Application for a Non-Material Amendment Following a Grant of Planning Permission

Retention of existing residential annexe, conversion of part of existing garaging to extend annexe, replacement of existing roof, including the addition of solar panels, adjustments to existing fenestration and application of external cladding, and associated works

DC/22/06217

BUILDING CONTROL	
Project/Client:	Project No:
Mulberry Farm	1743
Elmswell	Dwg No:
	100
	Scale:
	1:50
Drawing:	North:
ga plans	⊙ @ A1
Drawn By:	Date:
nb	26.05.23
Checked By:	Date:
nb	26.05.23

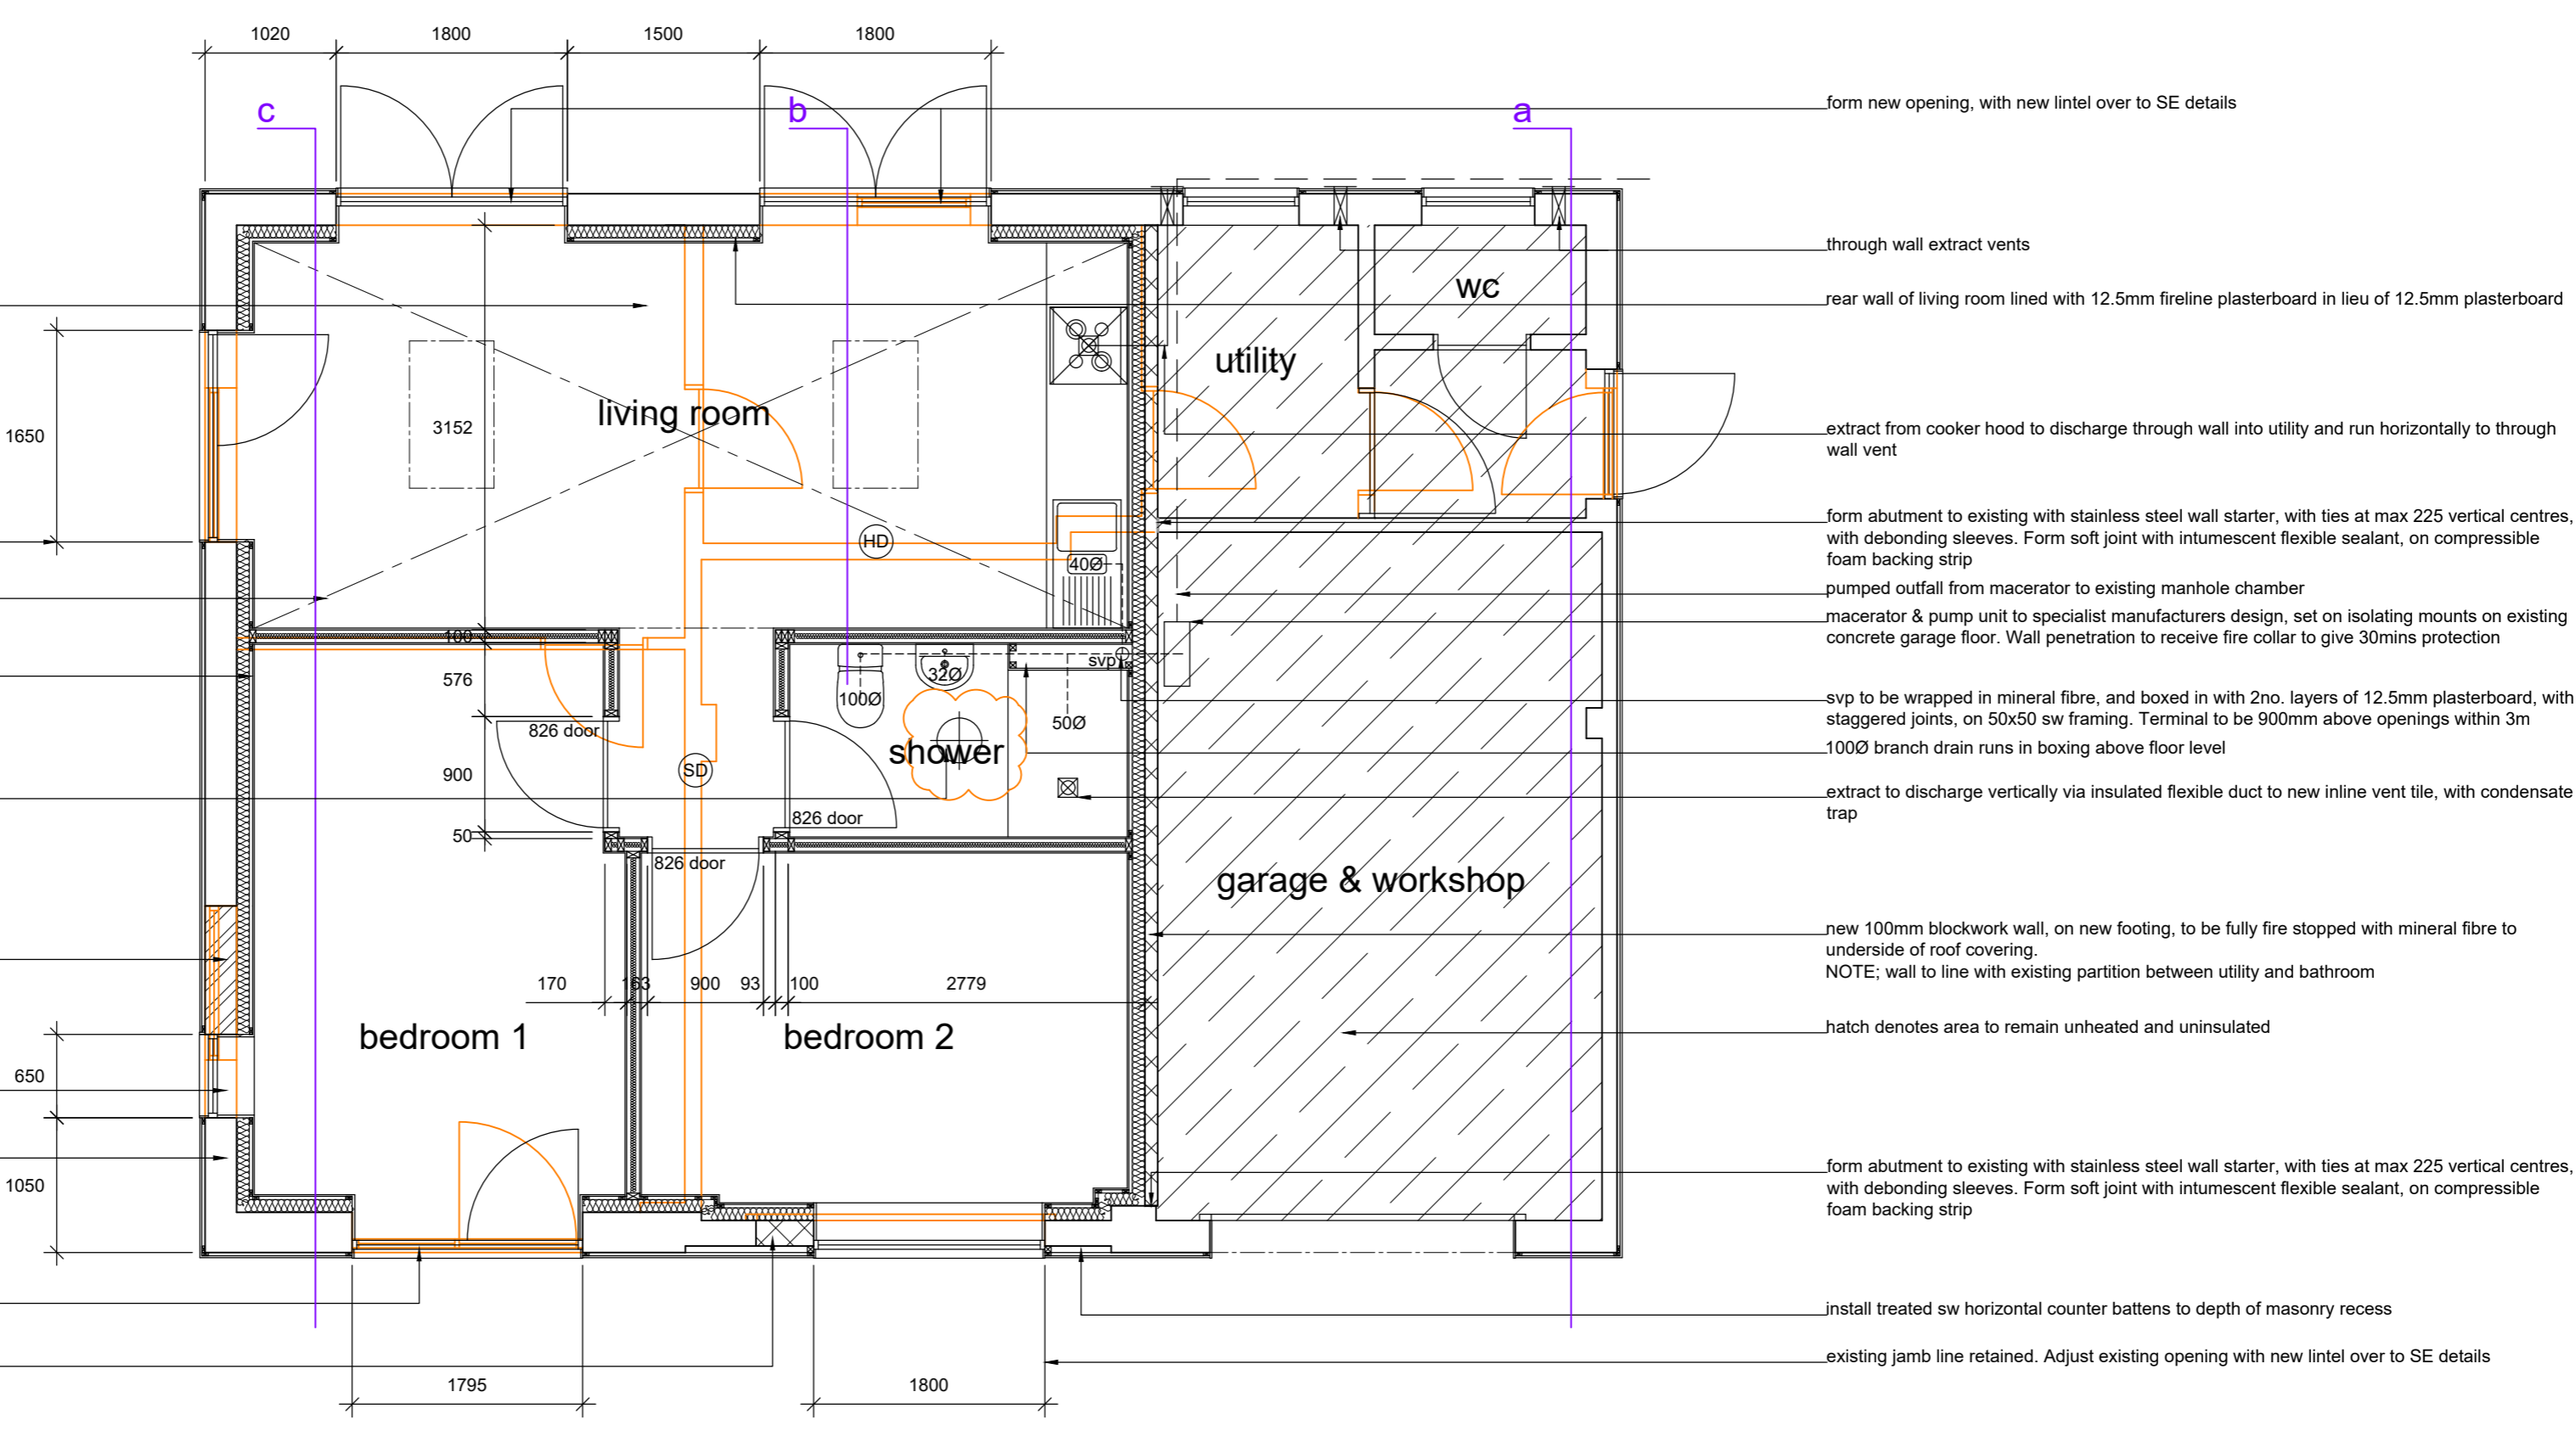
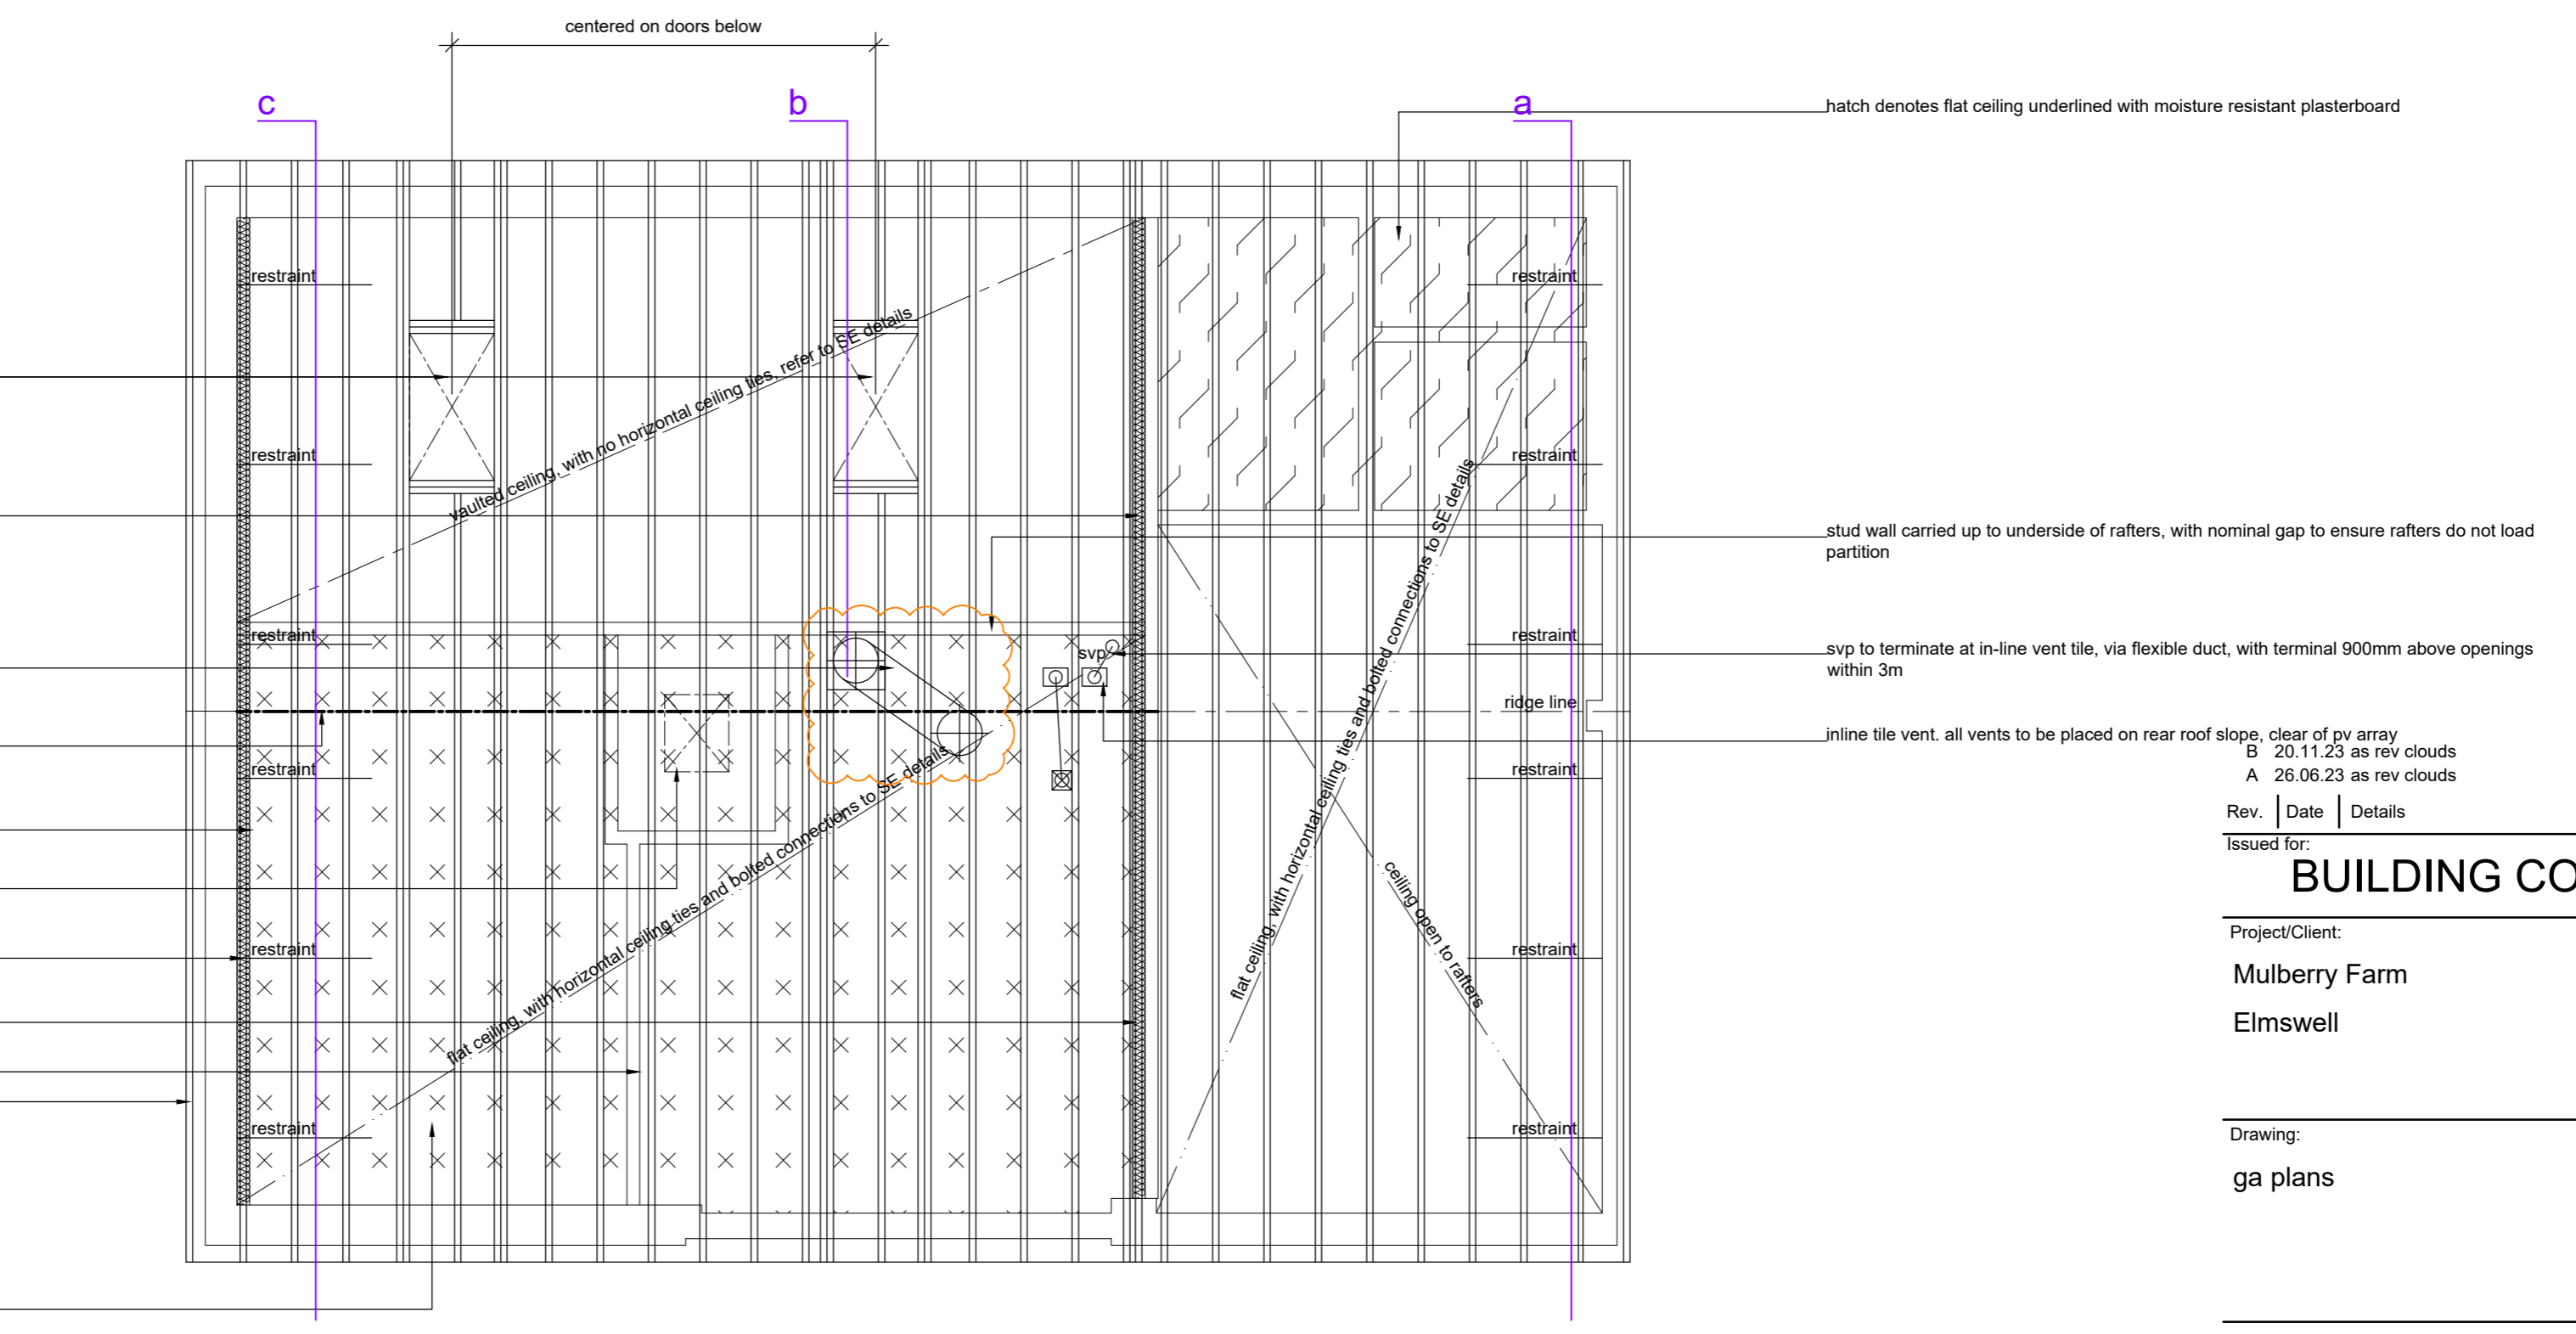
- Omission of woodburner and flue
- Installation of new sun tunnel to internal shower room, with external frame of the rear roof slope
- Omission of brick panels from south and west elevations
- Inclusion of aluminium / upvc windows & doors (as existing) in lieu of timber

To improve air quality, to provide light to proposed internal shower room, to improve aesthetics (brick panel in vicinity of flue no longer needed to resist heat, so timber cladding proposed throughout), for cost and maintenance purposes and to reflect the existing materials.
